Your Ref: OWPC22324
Our Ref: BR/63/19/PL 21-02-2019
Please ask for:
Stuart Corbey

Demolition of existing building and erection of 6No. three bedroom dwellings with associated accesses and car parking.

15-17 Kew Gardens Bognor Regis

Thank you for your internet representation made on 24th April 2019 which has been recorded as '**an objection**' with the comments as follows:

SITE SECTION FACING SOUTH
(1:100)

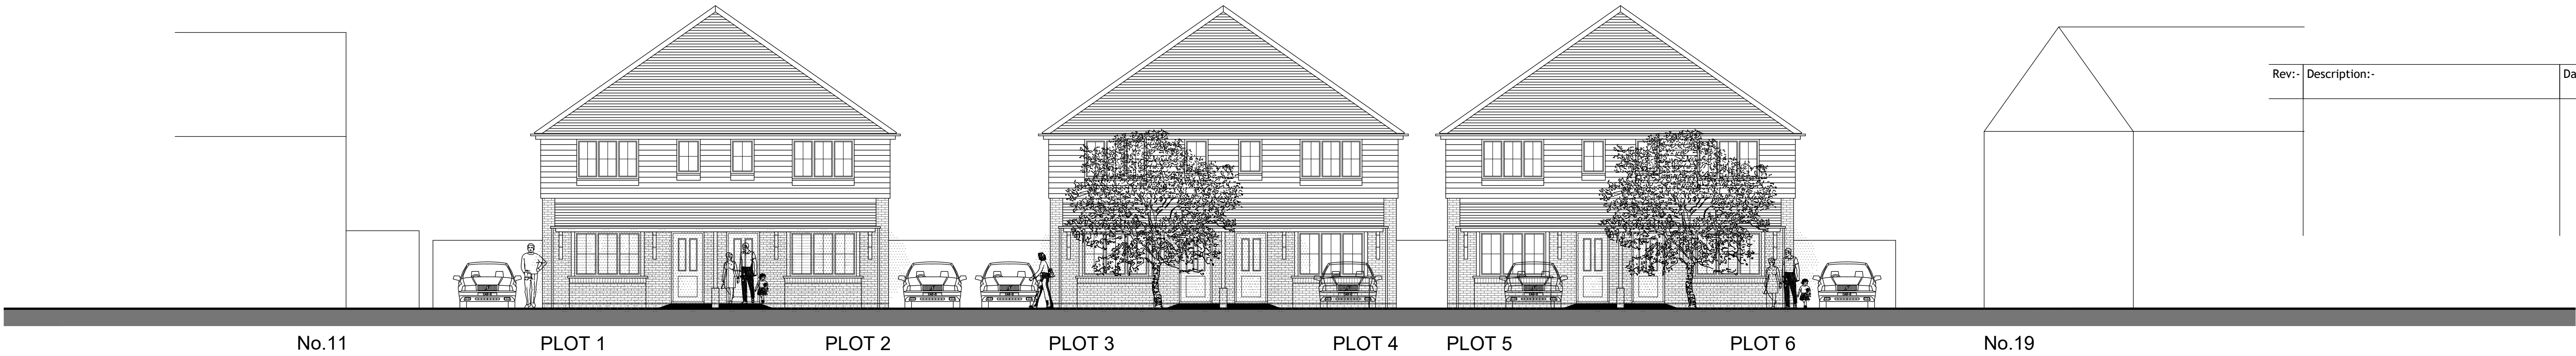
and will a) mean that our garden will now consist purely of a huge brick wall on the south facing side of our garden and b) blocking almost the whole days sunlight into our garden, patio and rear of our house.

BLOCK PLAN (1:500)

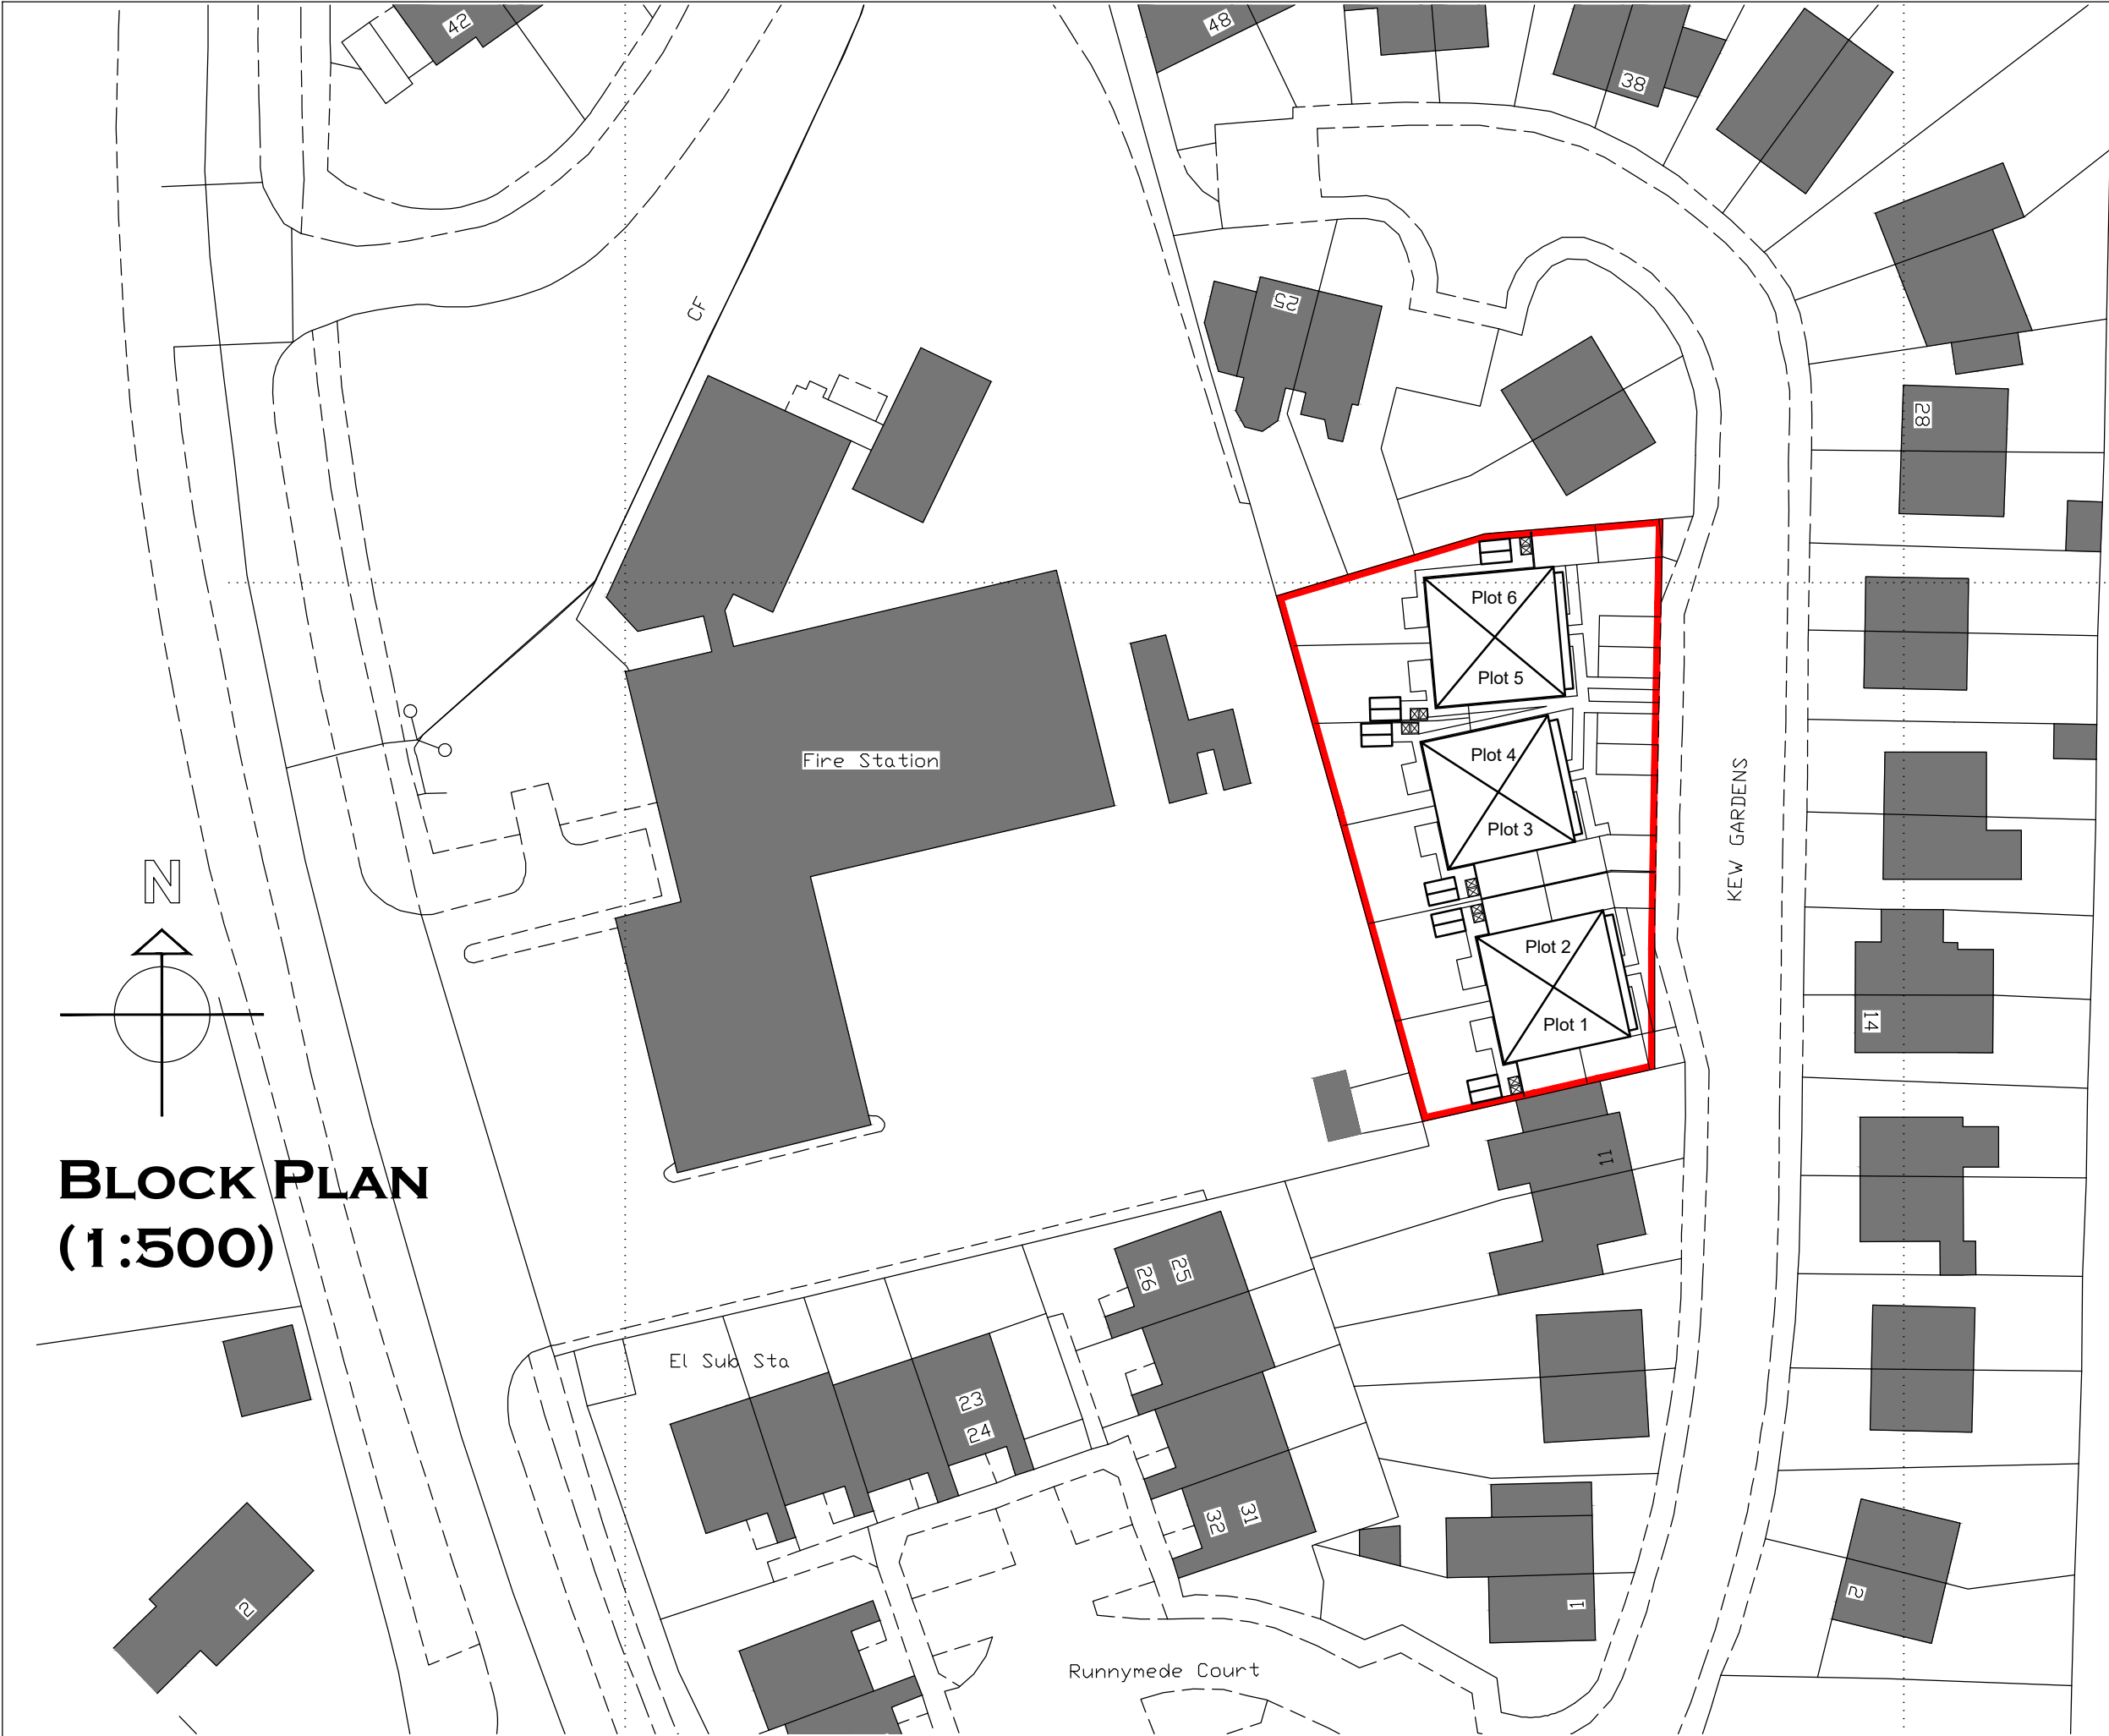
Firstly my major objection to this proposed development and main concern is the fact that plot 5&6 (and also plot 3&4) have been situated in such a way that they have been so heavily set back away from the road, which means that plot 5&6 which is a large semidetached plot of 2 x 3 bedroom properties will be a matter of feet away from our garden

I cannot understand why this proposed plot 5&6 has been set so far back as to where is will be overshadowing our garden. Although the developers may say they are looking to 'replicate' what is already in Kew Gardens this has not been followed as all driveways currently in Kew Gardens are between plots, this developer has pushed the driveways IN FRONT of their proposed plots in order to try and squeeze 6 properties onto the land rather than 4 which is what should be in keeping and replicate what is already in Kew Gardens. A sub-sequence of this is the houses especially plot 5&6 have been pushed back to now end up in line with our garden rather than the actual property.

I have concerns for the road as a whole, one of the main reasons being that why is the lay-by being removed? This is essential to help out cul-de-sac operate as its used throughout the day and night not only for visitors, but for tradesmen, carers and others. Also this keeps cars from parking on pavements which stops access for push chairs and wheelchairs - But the main concern is if the lay by is removed and we then enter a situation where cars are parking on pavements and partially blocking the road what then happens if emergency services need to attend the end of the road and we have cars blocking the way?
